**Marist Catholic College North Shore (SSD-10473)
Response to Submissions**

ATTACHMENT 1

Drawing No. DA-010	Issue D
Scale As indicated	Drawing Size A1
Project No. 18165	Drawn By BE

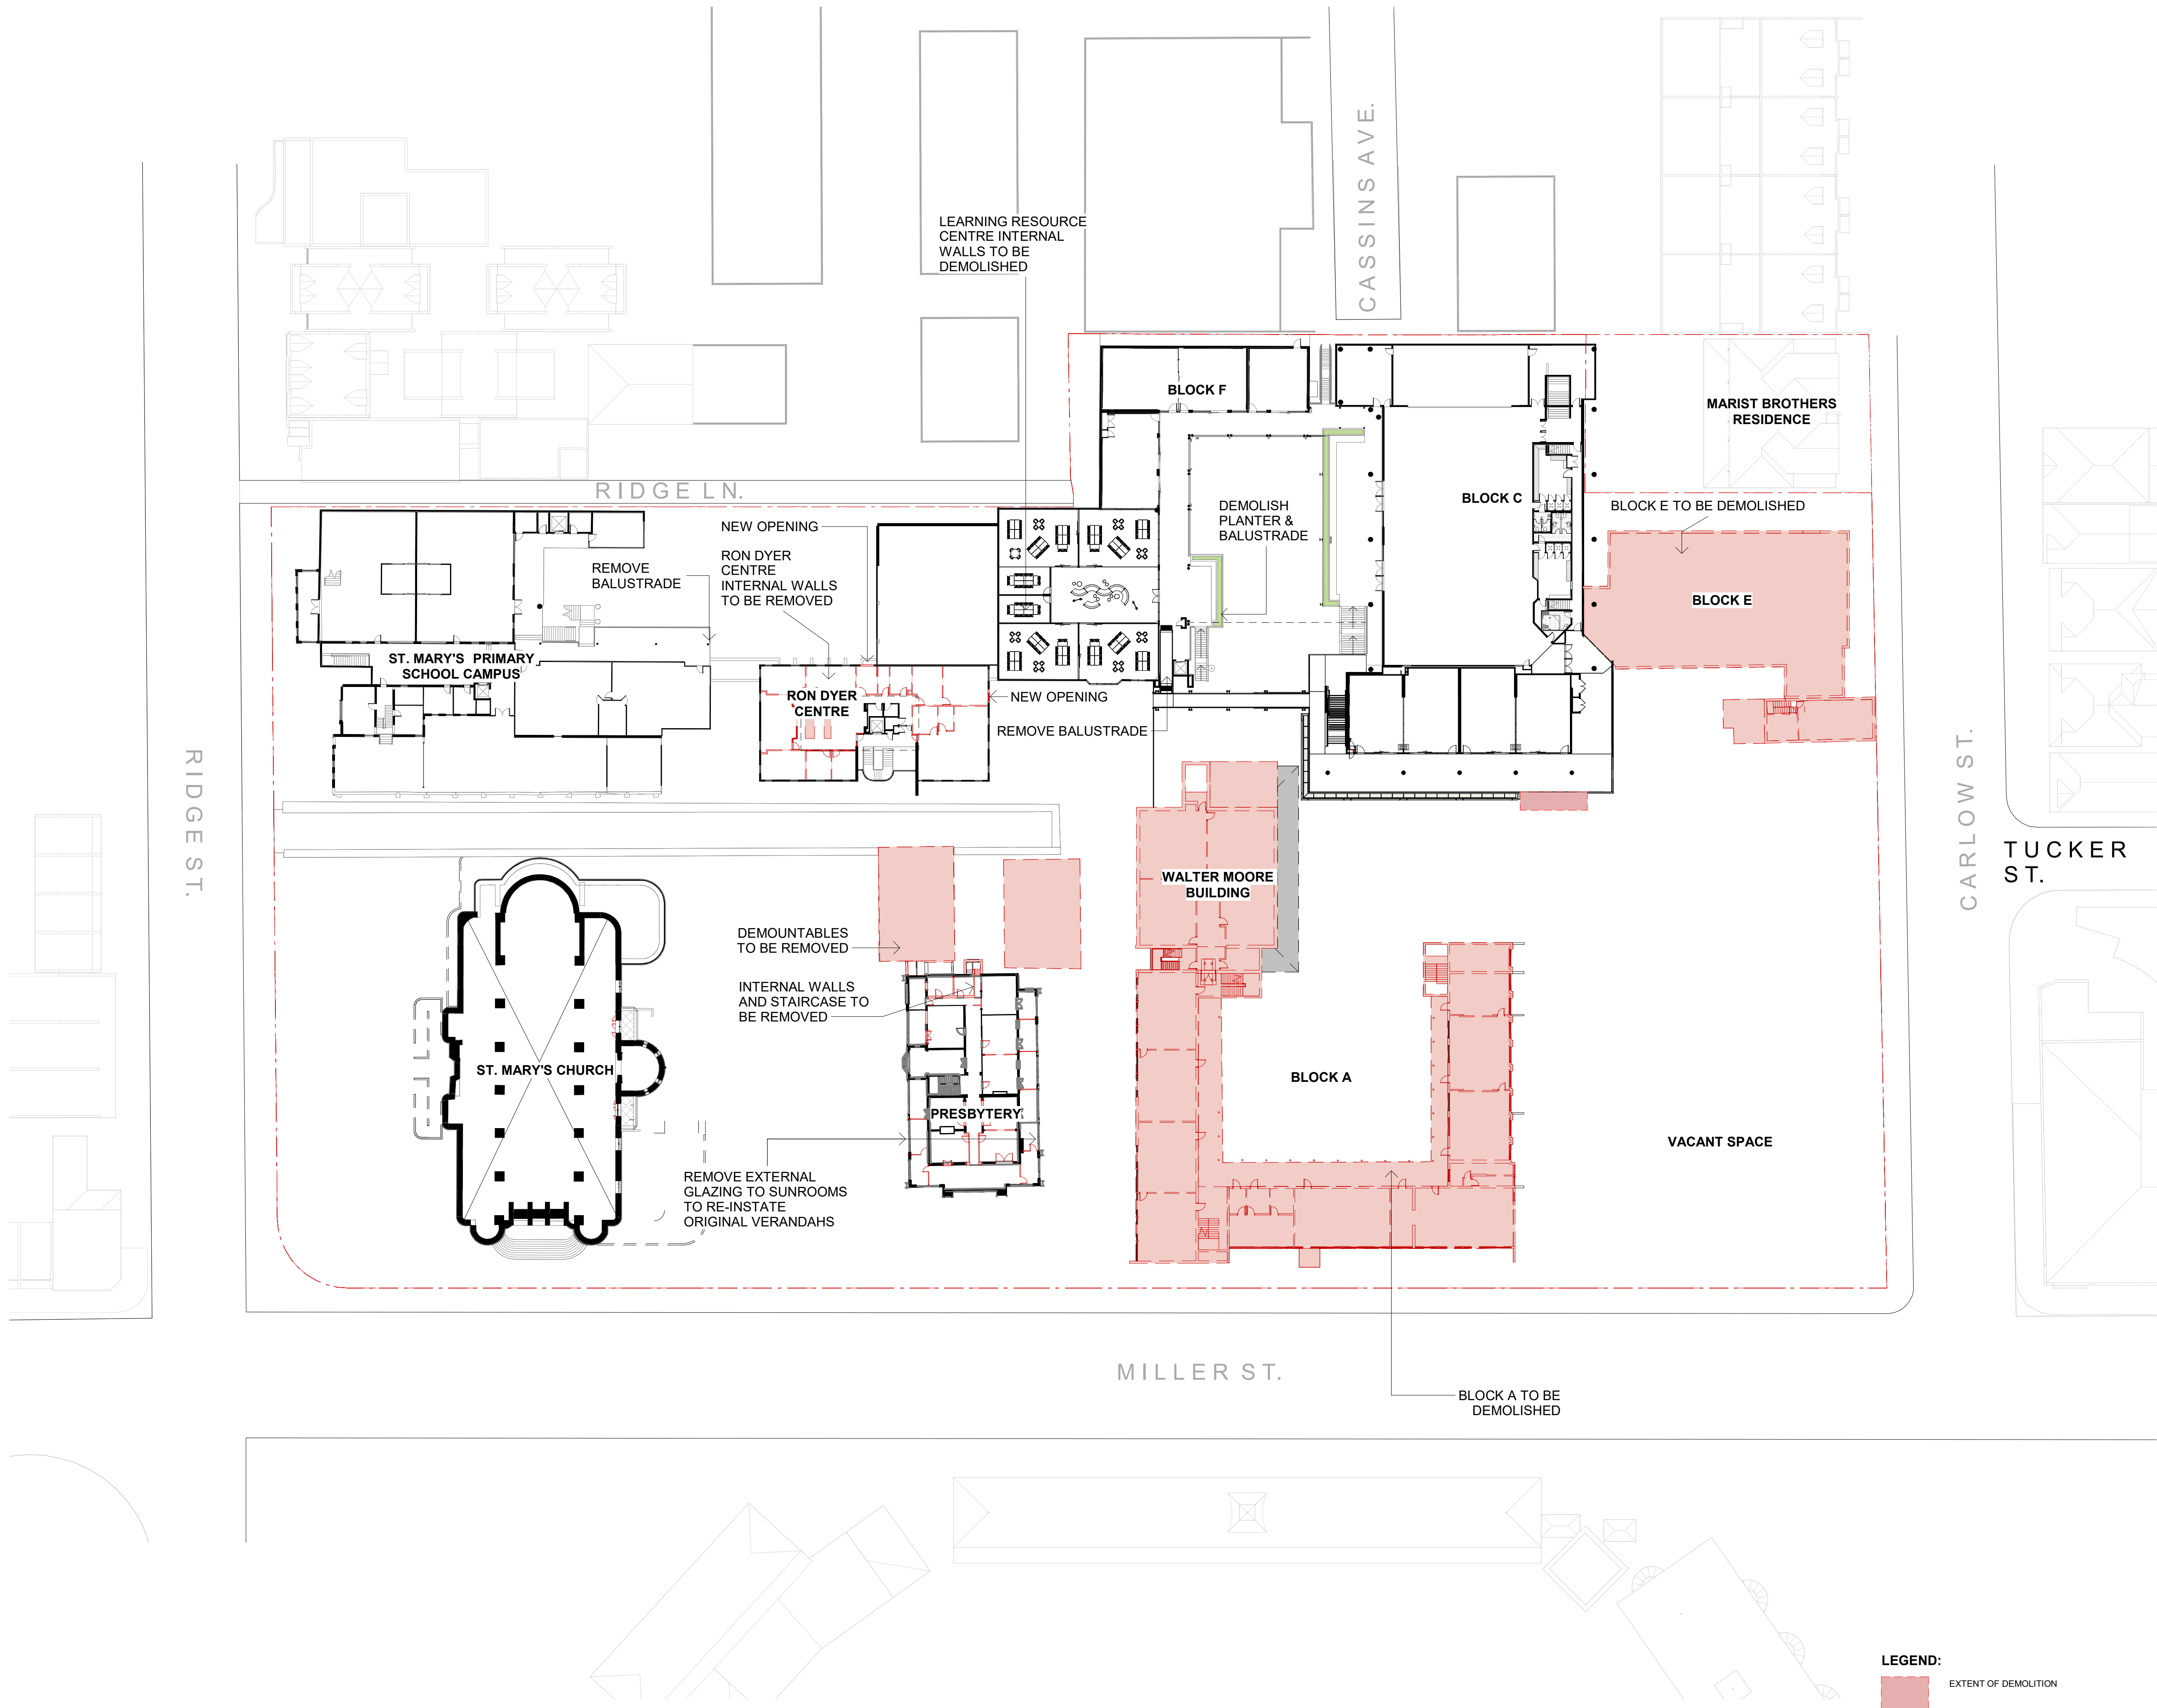
- the scale of the drawings should be mentioned in the plans. The architectural plans (demolition and proposed) should more clearly identify where wall nibs are to be retained to maintain the legibility of the original layout.

- The demolition drawings continue to show the two terraces, Jacaranda Cottage and other site preparation demolition works for which separate Council DA approval has been granted (DA100/21) and no longer form part of this application. Either remove these works or include a clear annotation with colour change confirming separate approval has been granted for these works and they do not form part of this application.

The demolition drawings include an annotation that that demolition of Block C Annex “Note: Proposed development subject to separate approval”. This being the case, remove the demolition of this building from the demolition drawings.

Drawing No. DA-101	Issue D
Scale 1: 200	Drawing Size A1
Project No. 18165	Drawn By BE

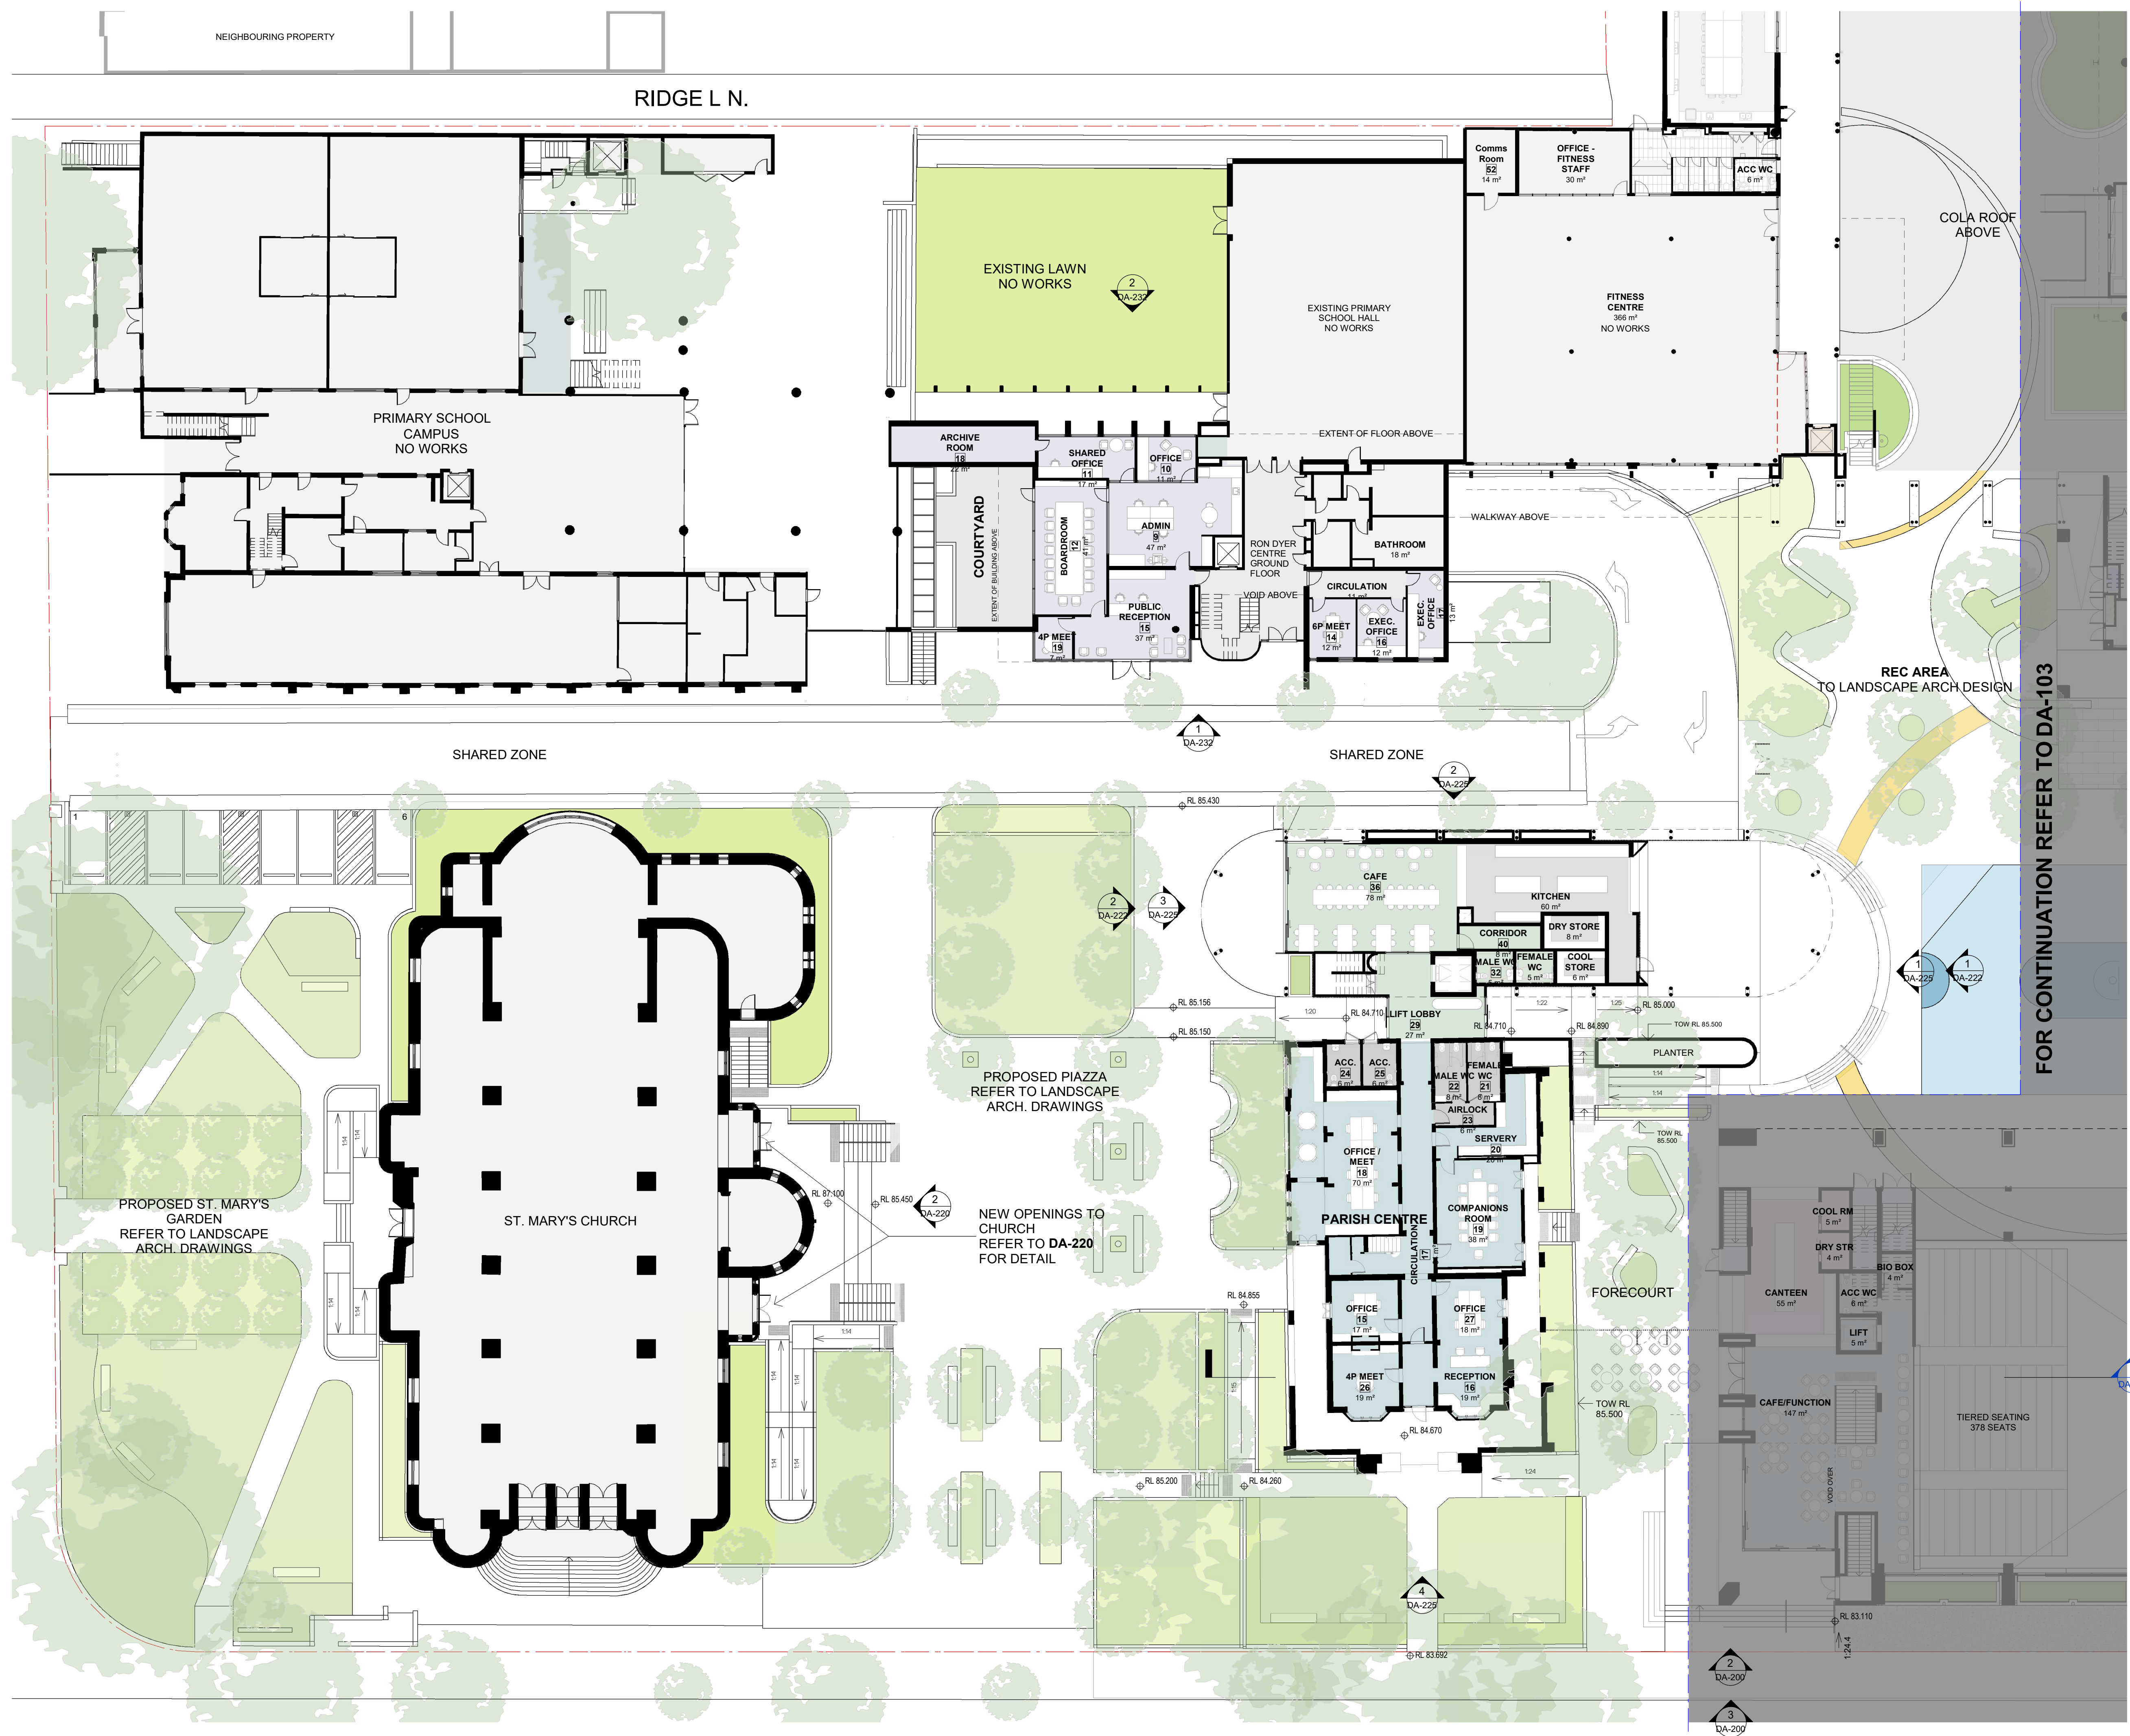
- clarification of the proposed allocation of parking spaces, in particular:
 - at the basement level of the Carlow Street building, noting the RtS states there are 50 staff parking, 9 childcare, 12 PUDO. However, the architectural drawings indicate 48 staff parking, 10 childcare and 13 Years 2-12 PUDO.

1 TEMPORARY BUILDING PLAN
SCALE 1 : 400

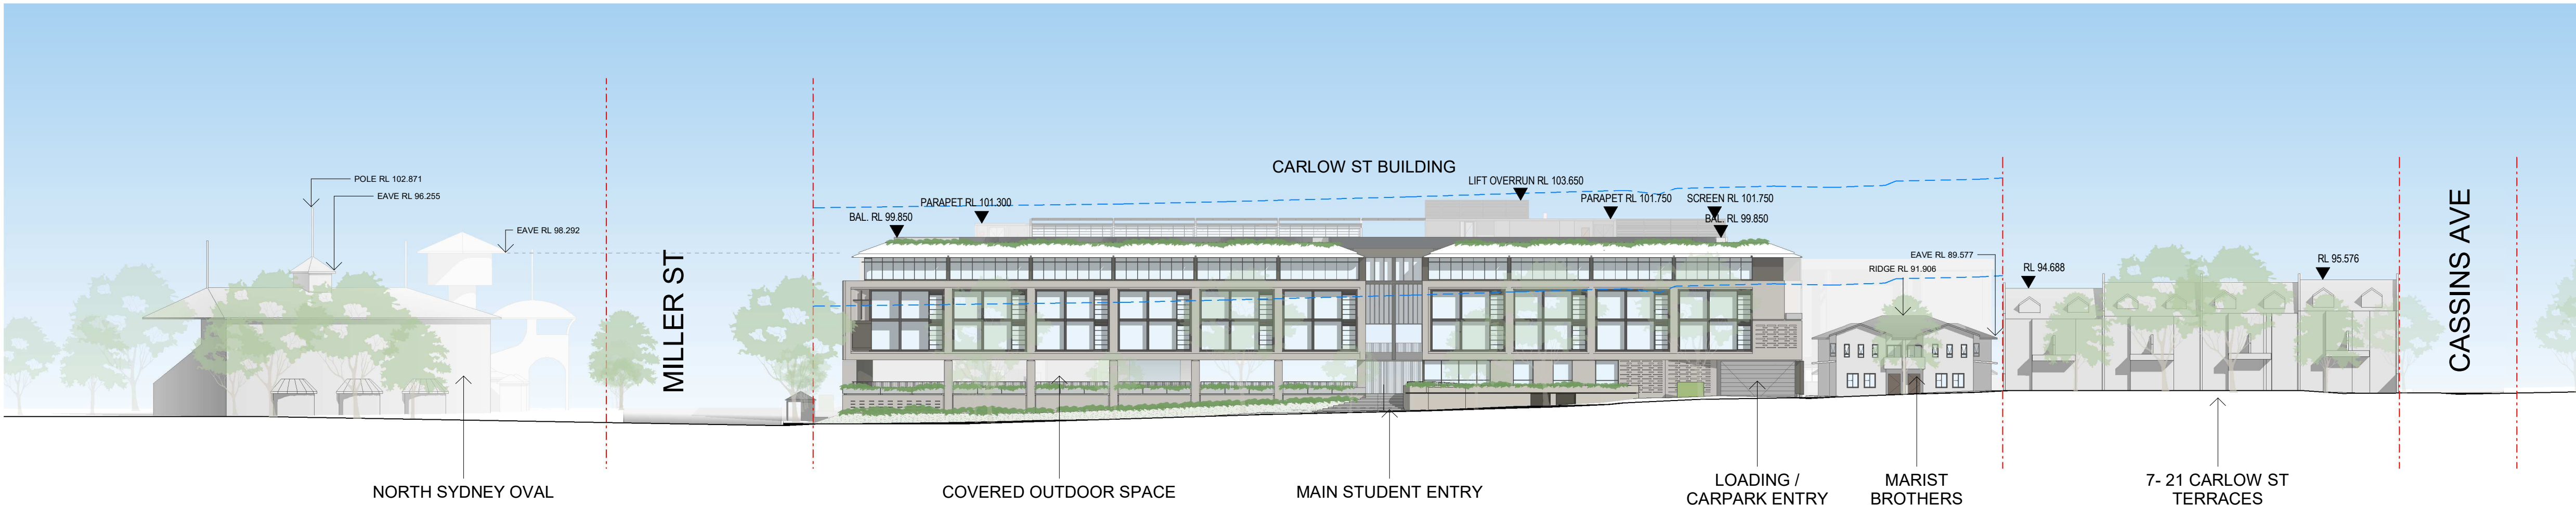
- updated DA-802 (CGI) to reflect the RtS amended Miller Street building.
- include a temporary building plan and elevation(s) for the proposed portables / temporary classroom(s) etc during construction. In addition, confirm the predicted life-span of the temporary buildings and the trigger/timing for their removal.
